29. BERKELEY CT.
THE ESPLANADE.
BOGNOR REGIS.

BB/75/19/CLE

I am writing to you because of my concern in the plans for the three-bedroomed flat.

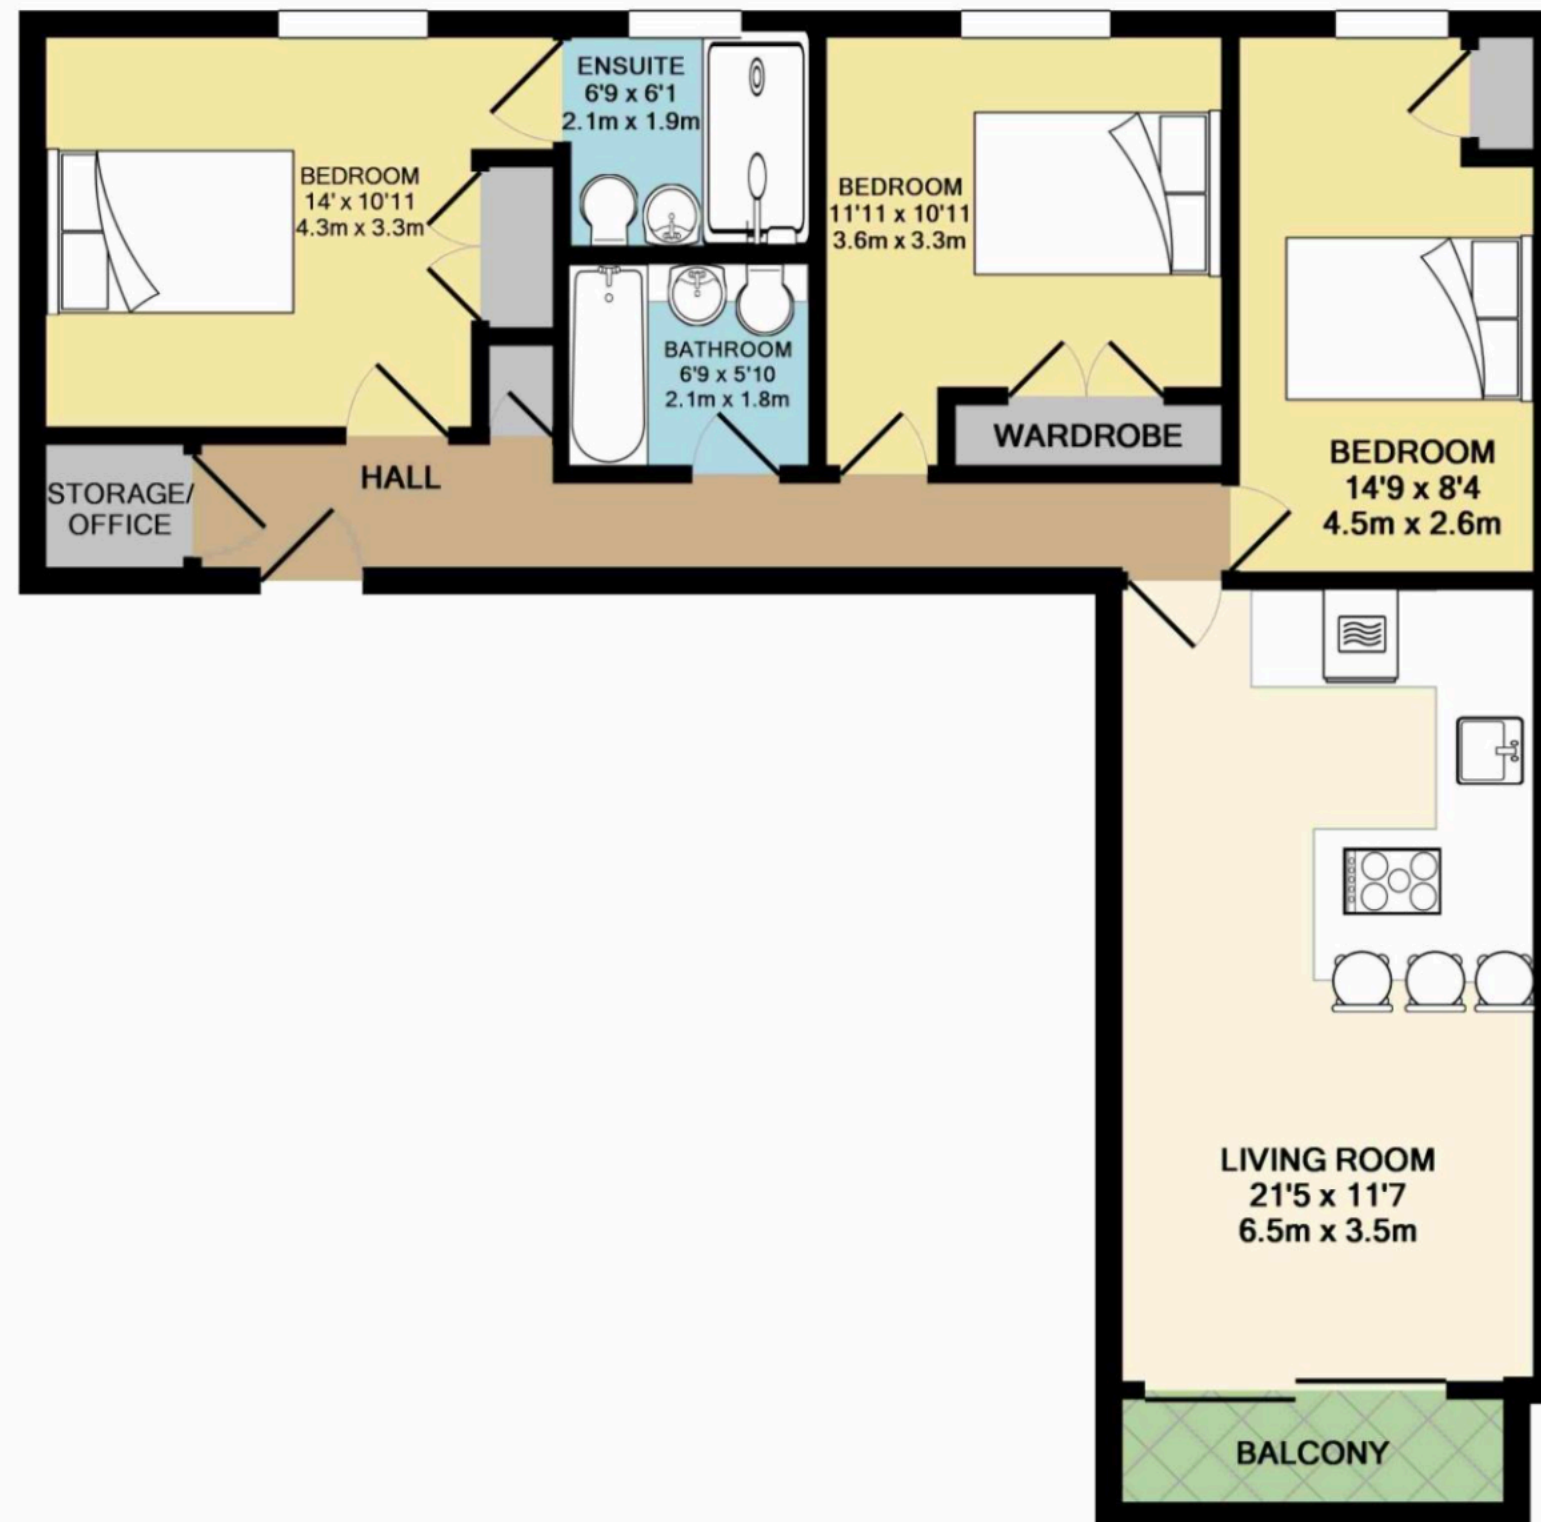
The boiler in the bedroom could be quite a hazard and a problem for others if there was a water leak.

Also a kitchen without any window or air vent to me, is not ideal.
